APPROVED
 Limited building only review.
 Permit holder responsible for full compliance with the code.

Plan No 1920-10

SHEET A-1	YUNCANNON DESIGNS CUSTOM HOME PLANS FUQUAY-VARINA, NC - (919) 421-1374	Mitchell/April Womack Old Buies Creek Rd Buies Creek, NC
---------------------	---	--

SHEET
 A-1

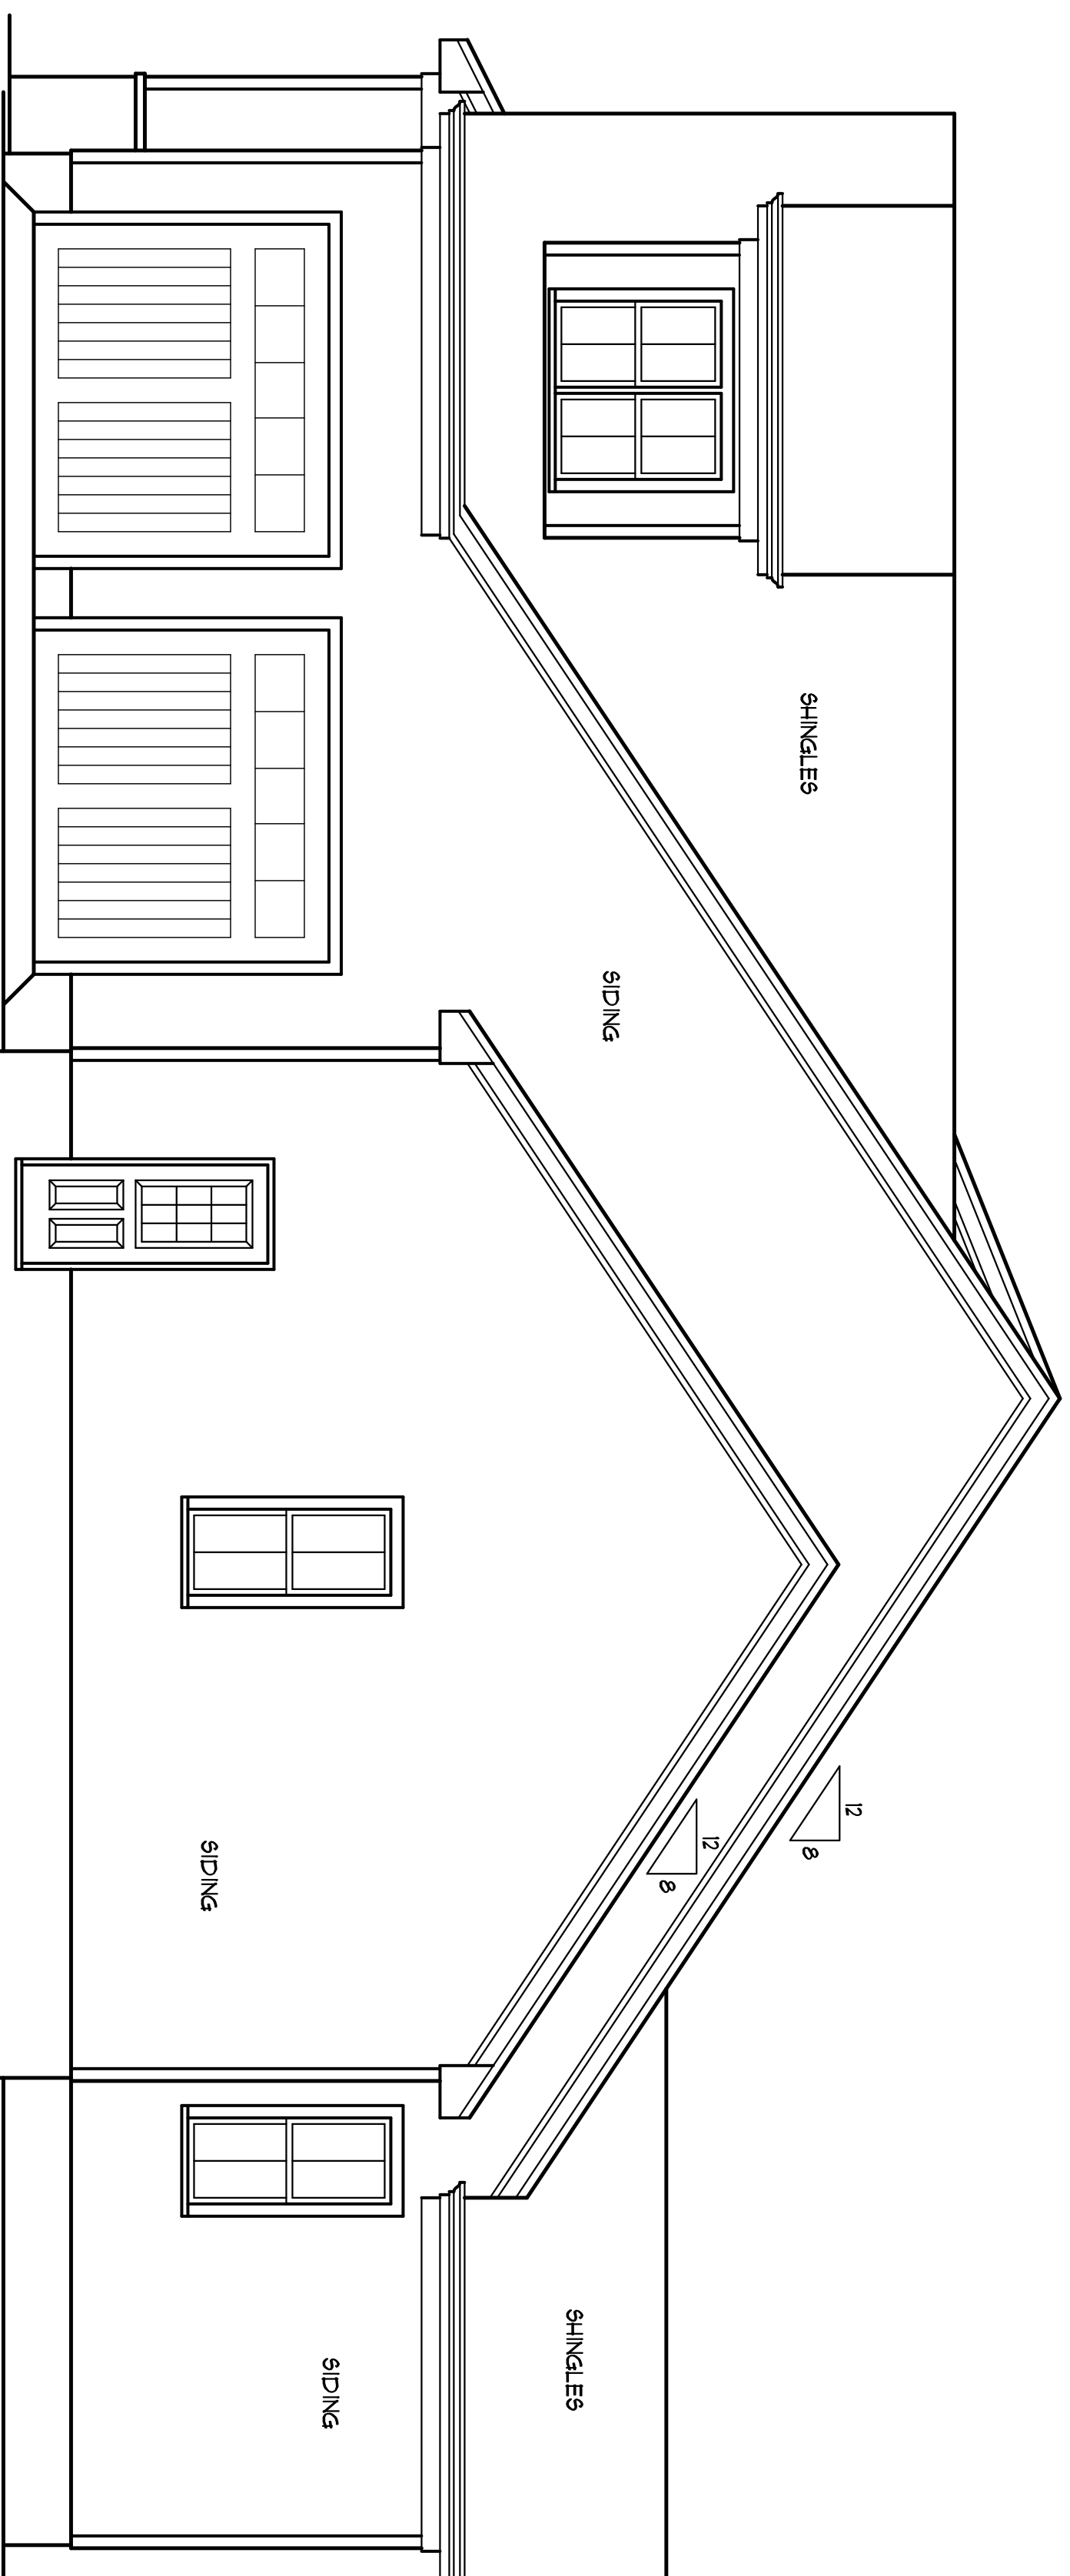
Field verify egress window sizing. Typically, double hung 4/6 windows will not open to the minimum height required by NCR 2018.
